**RE: Davis Residence  
Grading and Drainage Plan  
Engineer's Stamp Date 6-9-2016 (File: J17D037)**

**From:** Abiel X. Carrillo  
**Sent:** Wednesday, June 08, 2016 11:54 AM  
**To:** 'Mike Walla'  
**Cc:** 'Kindel@edi-arch.com'  
**Subject:** Davis Residence - J17D037 - Stamp Date 5-24-16

Based upon the information provided in the submittal received 5/27/2016, the Grading and Drainage Plan cannot be approved for Building Permit until the following items are addressed:

SITE/ROOF PLAN
PROJECT
INFORMATION

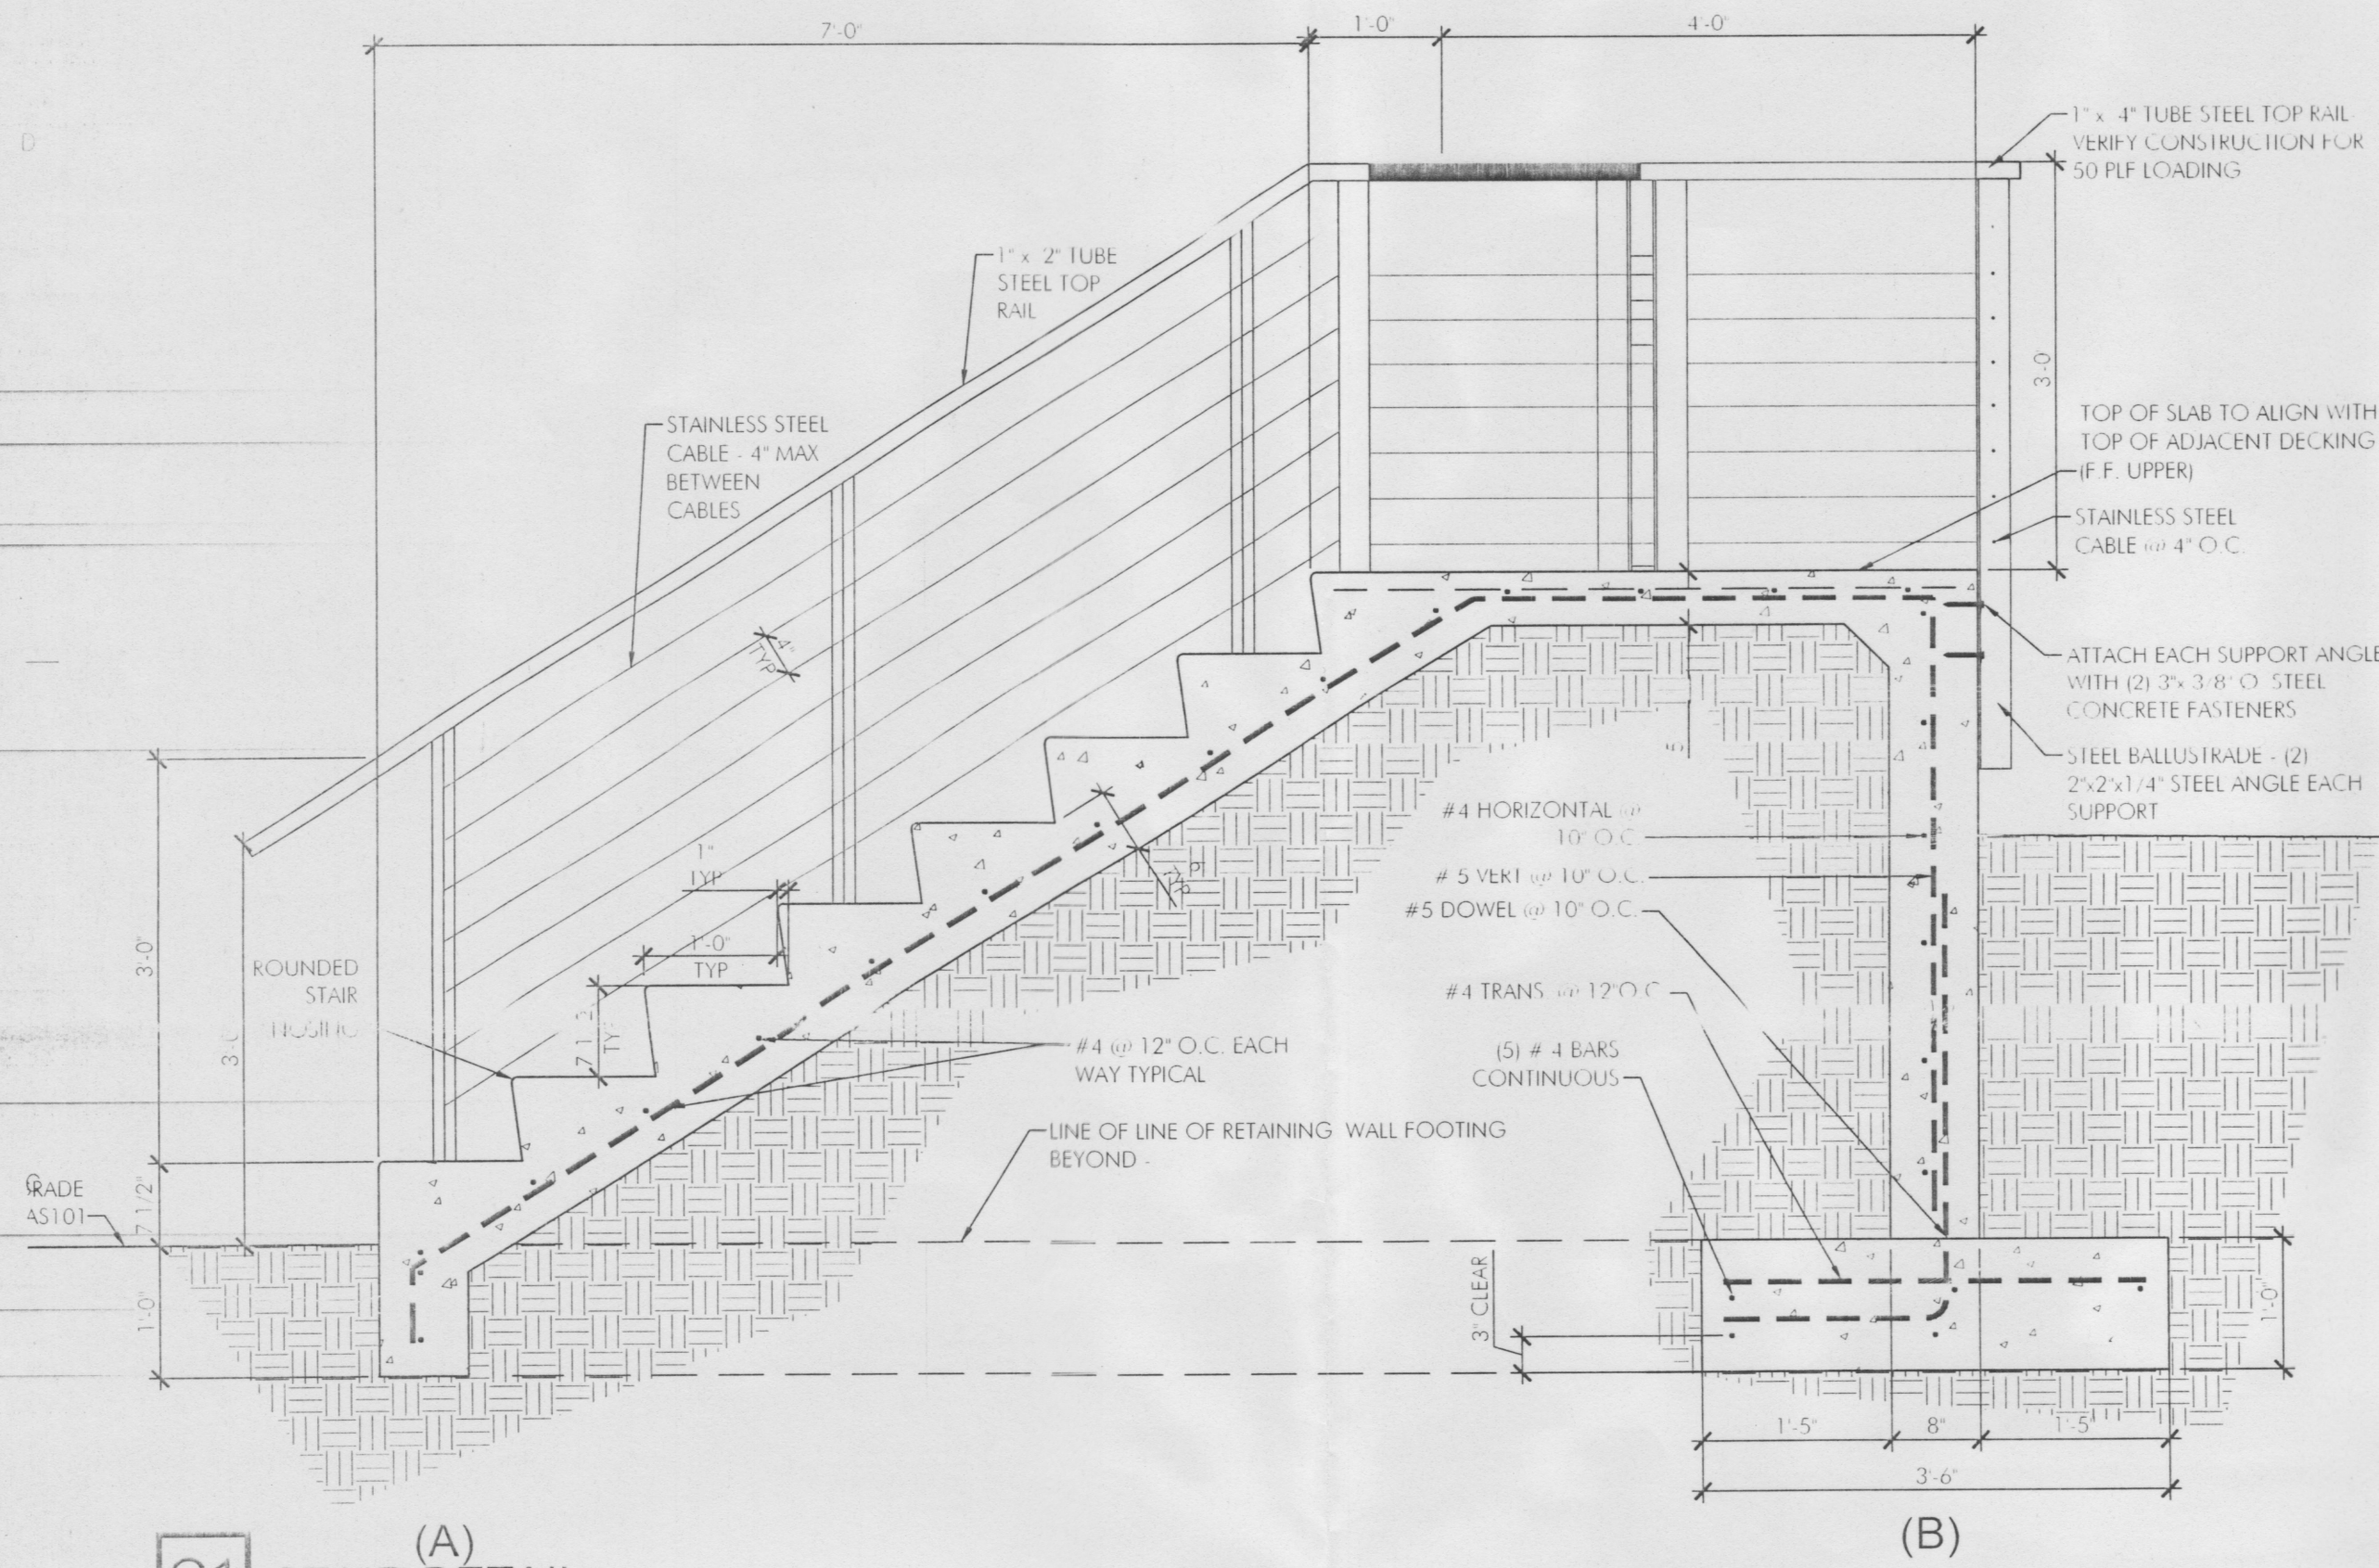
1. The outlet of the 2" PVC forced drain line should be set behind the property line, since PVC lines are not allowed in the Right of Way.
2. The sidewalk culvert needs to be inspected by the City, which is accomplished through the SO-19 procedure. Please attach the enclosed SO-19 Notes to the Grading Plan.

3. The sidewalk culvert plate should extend 1-foot behind the sidewalk.
4. Call out the City's Standard details for curb and sidewalk replacements associated with the removal of curb cuts.

5. Add a note to the plans that removal of sidewalk and curb and gutter shall be done to the nearest joint.
6. Please consider incorporating a measure to keep the french drain from plugging with sediment and reducing the frequency of needed maintenance, such as wrapping the top rock layer, or the grate bottom with filter fabric. Depending on the proposed measure, the bottom mat under the CMP should also be wrapped to help preserve the capacity of the outlet.
